October 18, 2016

Re: Taco Bell Conversion
1363 Washington Avenue
Portland, Maine
BD#2016-02255

This correspondence is in response to the Review comments sent by email dated October 13, 2016, we offer the following:

TITLE SHEET

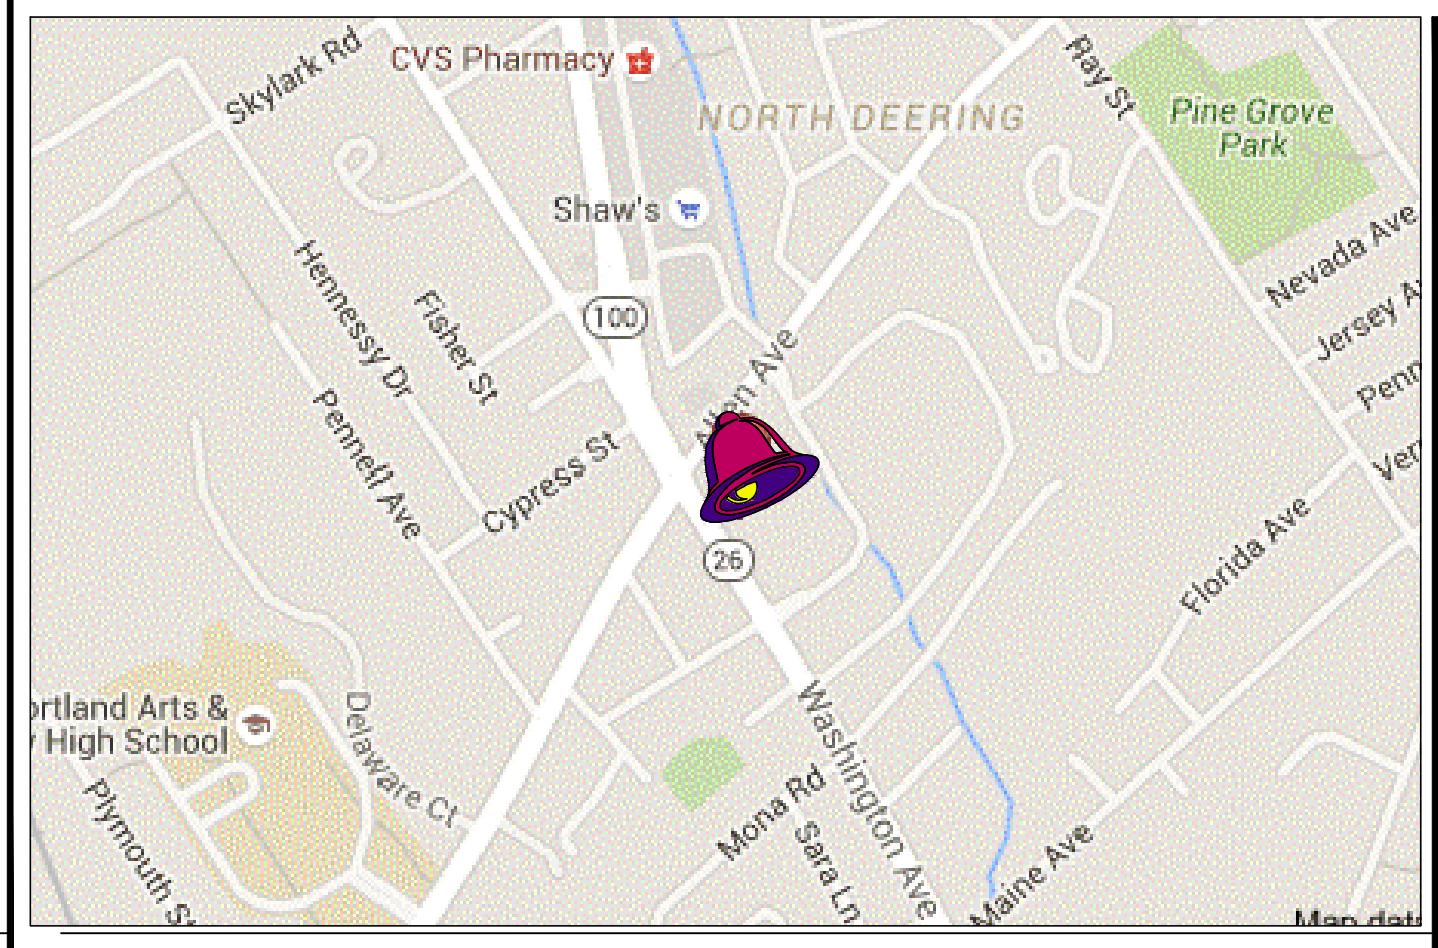
Response to Comment 1: Sheet T1.0, Title Sheet:

- A. Updated revised Sheets as noted.
- B. Added the following Sheets to the Index:
 - 1. LS1.0 – Life Safety.
 - 2. D1.0 – Demolition Floor Plan.
 - 3. D3.0 – Demolition Exterior Elevations.
 - 4. A9.0 – Site Details.
- C. Updated Sheet numbers and names of Structural Drawings.
